Re: Variation of Condition 2 pursuant to planning permission APP/P0119/W/23/3314689.

I am writing in my capacity as planning agent acting on behalf of the “**Applicant**”, Cordage Estates Limited, to formally request a Variation of Condition 2 pursuant to the above planning application at King William IV, 30 Tower Road, South Warmley, South Gloucestershire, BS30 8BL (the “**Property**”).

“Demolition of extension and entrance porch on existing public house. Erection of a convenience store (Use Class E), creation of new access/egress off Tower Road South to serve reconfigured car park for pub and convenience store, new delivery bay and associated hard and soft landscaping. “

Permitted plan “22 Aug 2022 10.00 M PROPOSED SITE PLAN, 22 Aug 2022 10.01 V PROPOSED FLOOR PLANS, 22 Aug 2022 10.02 L PROPOSED ELEVATIONS and 22 Aug 2022 10.11 J PROPOSED INDICATIVE STREET SCENES” is to be substituted with proposed plan “24.3436.101 Rev P1, 24.3436.102 Rev P1, 24.3436.103 Rev P1 and 24.3436.104 Rev P1”.

Drawing No.	Revision	Scale
24.3436.102	P1	1:100 A2

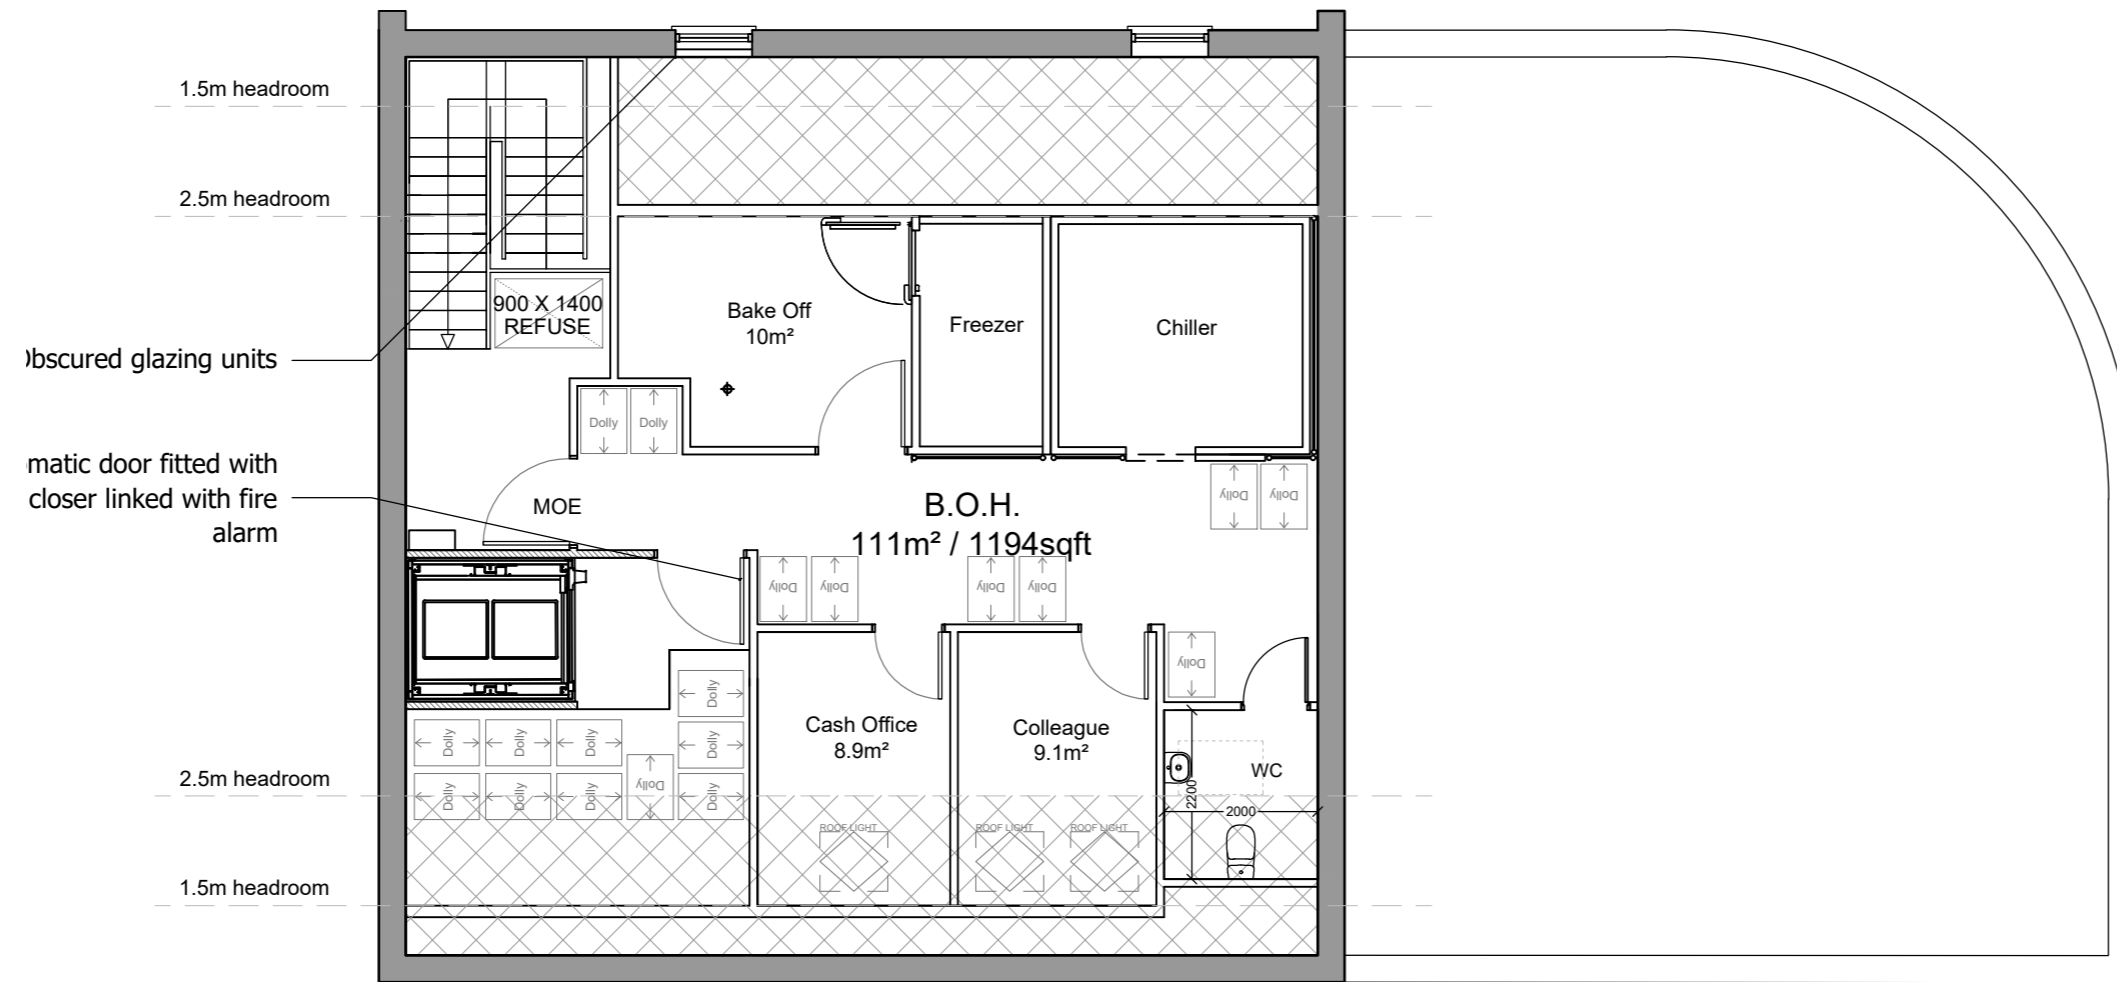
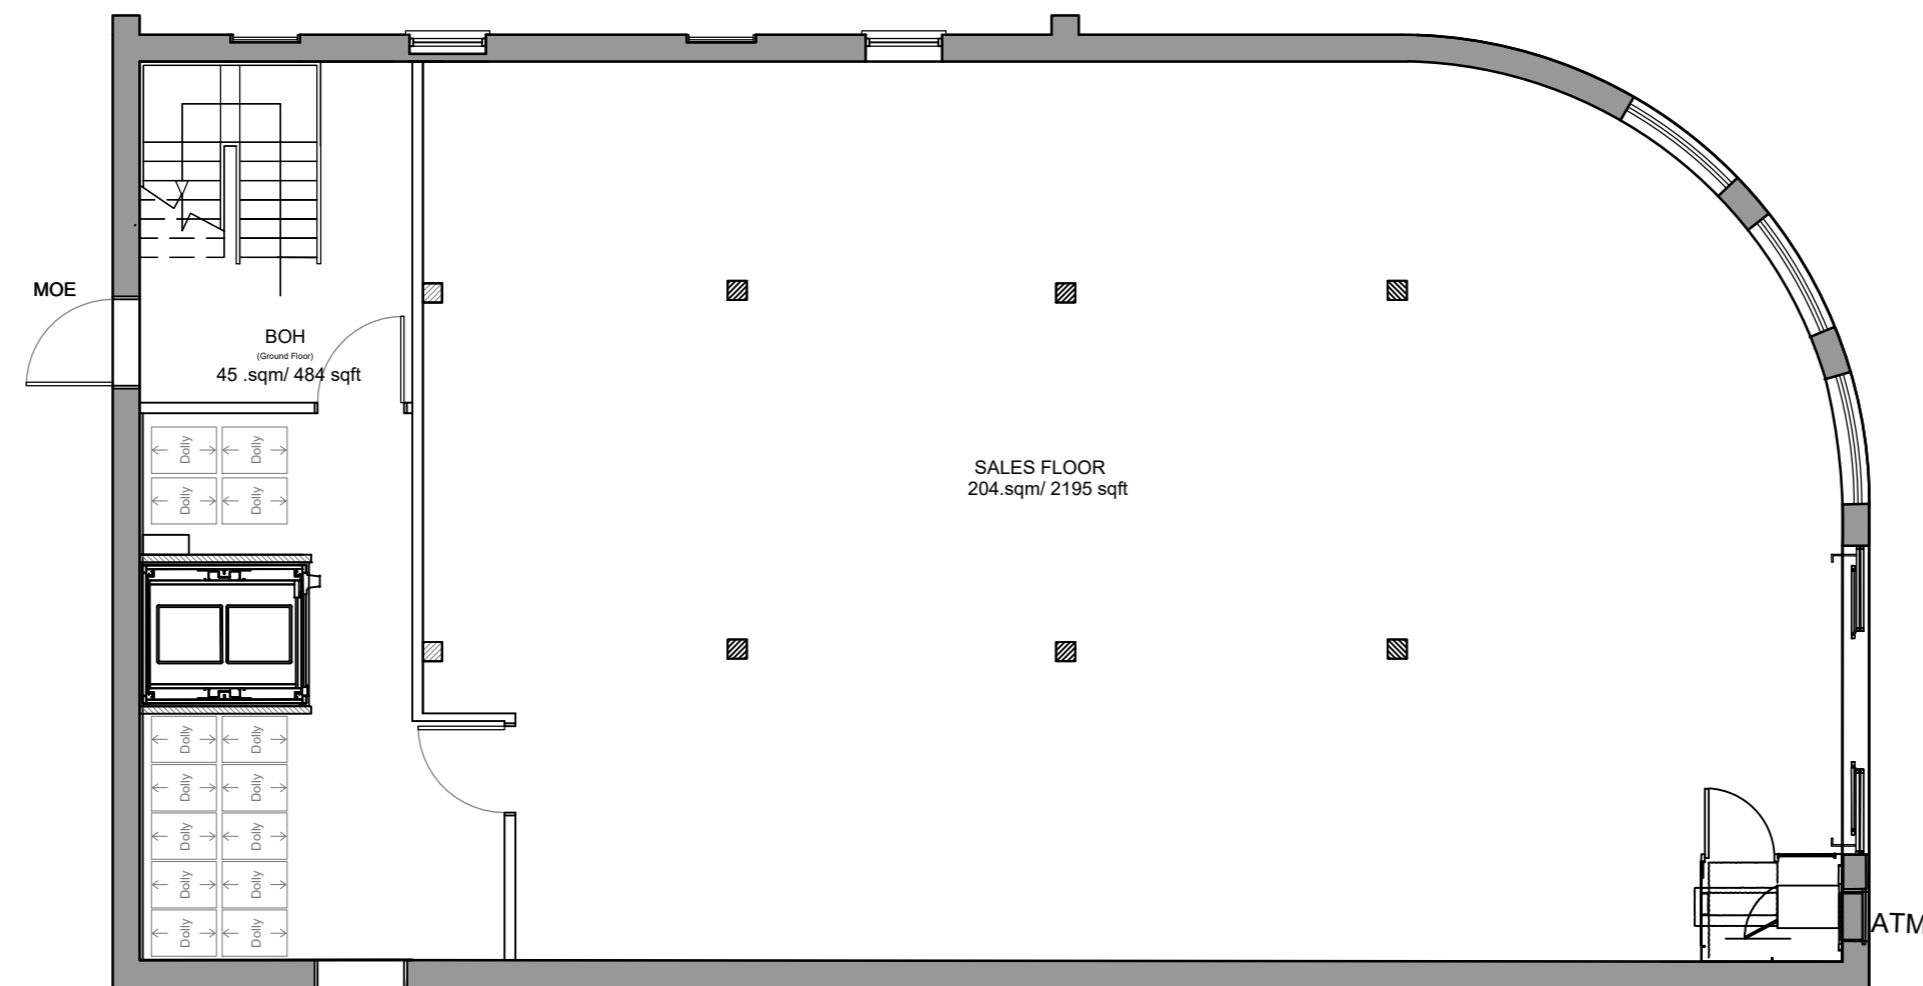
- The roof design of the two storey element has been simplified, with the east gable now faced with stone.
- The pitched roof above the single storey element has been replaced with a parapet design.
- The western elevation is to be rendered.

Drawing No.	Revision	Scale
24.3436.103	P1	1:100 A2

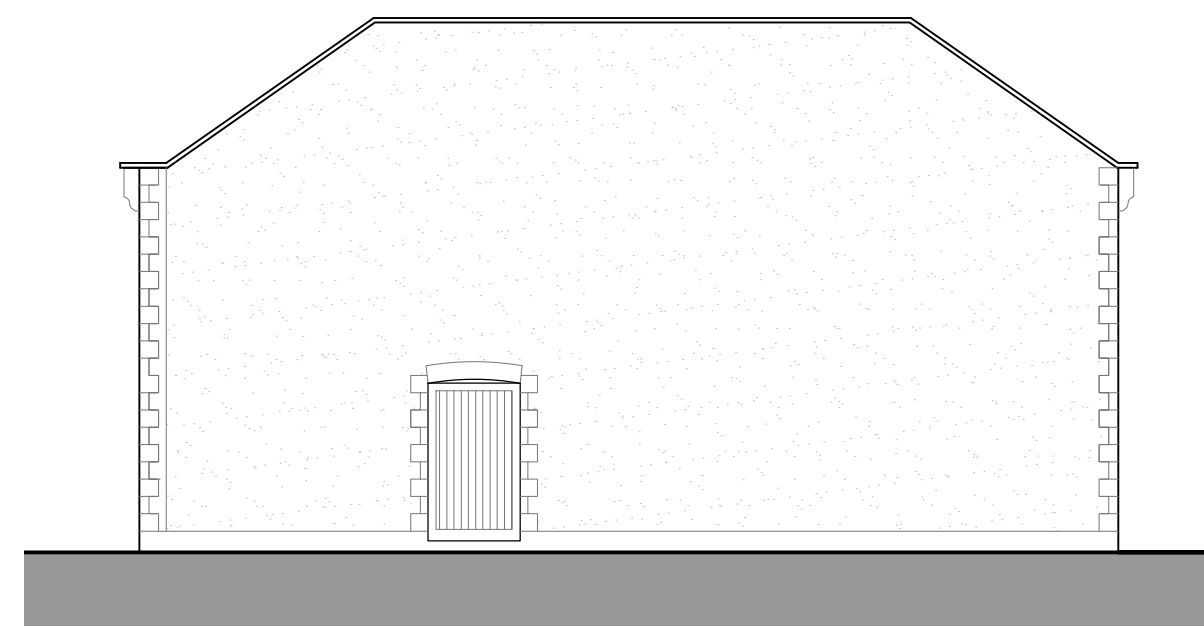
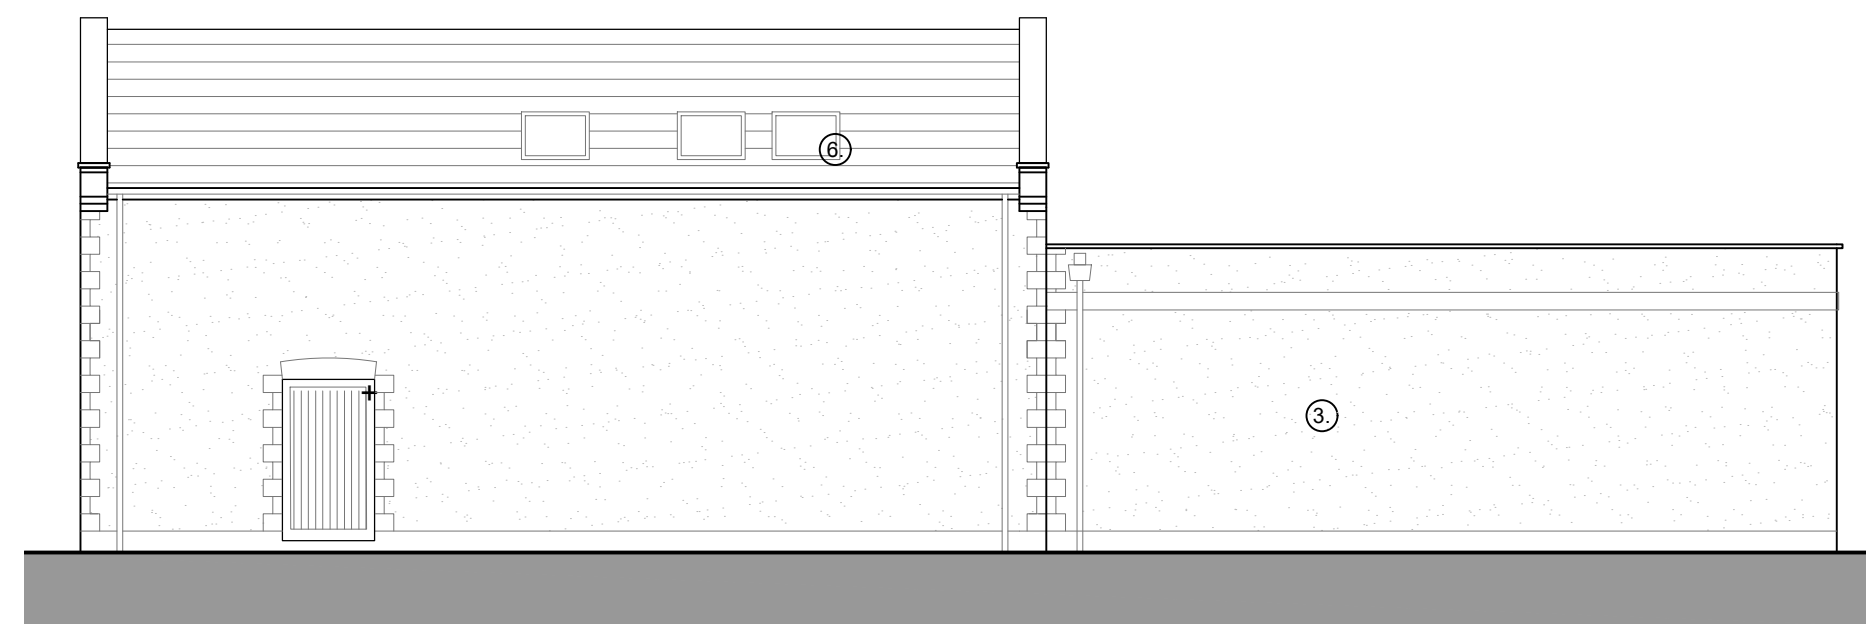
The Applicant wishes to make the above changes which are considered to be more sympathetic to the existing building and local character.
